From: Michael Eastham
Sent: 31 July 2019 14:13
To: Planning.Responses
Cc: Nicola Spencer
Subject: FW: *EXTERNAL: LU/241/18/PO - Location Plan
Attachments: Revised Site Location Plan LEAP 31.07.19.pdf

From: Michael Eastham [REDACTED]
Sent: 31 July 2019 13:31
To: Sparkes, Jess [REDACTED]
Cc: Havis, Sean [REDACTED]
Subject: *EXTERNAL: LU/241/18/PO - Location Plan
Importance: High

Please could you amend the attached location plan by:

Client
Gleeson Developments Limited
Project
Courtwick Littlehampton
Description
Plan 2

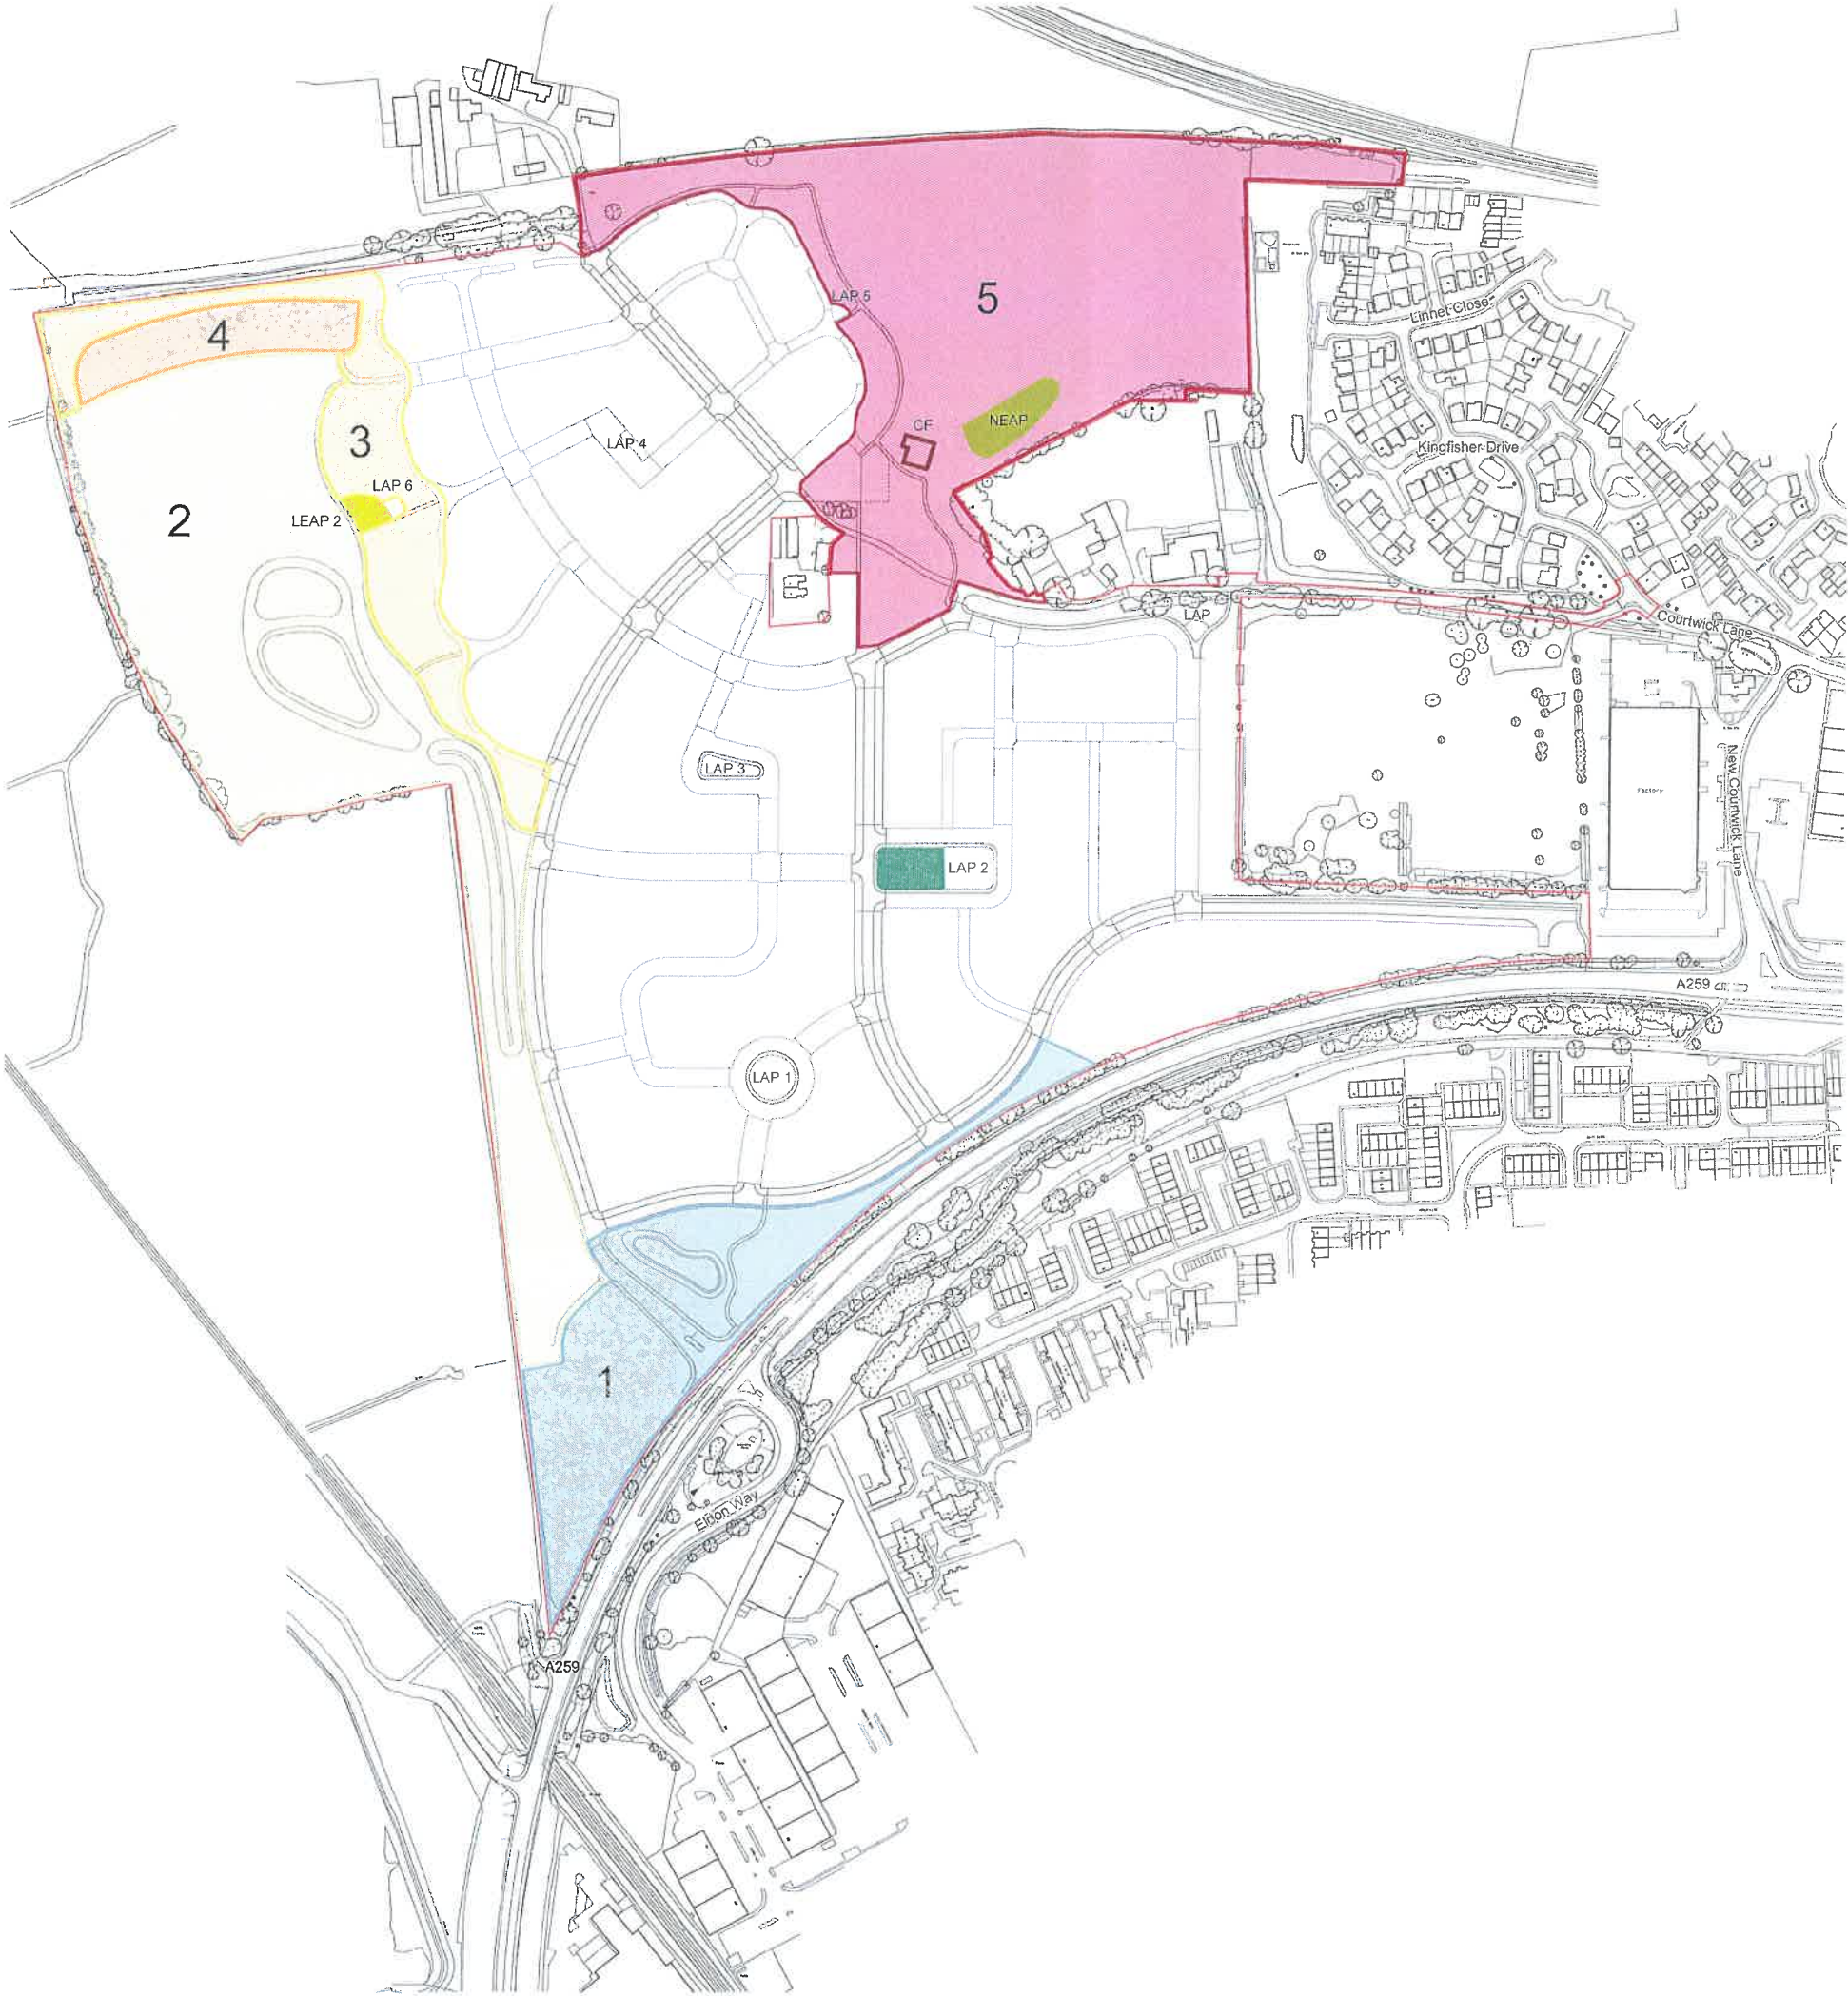
- 1) revising the key to read “LEAP” (i.e. remove “LEAP 2”);
- 2) removing “LEAP2” and insert “LEAP” on the plan.
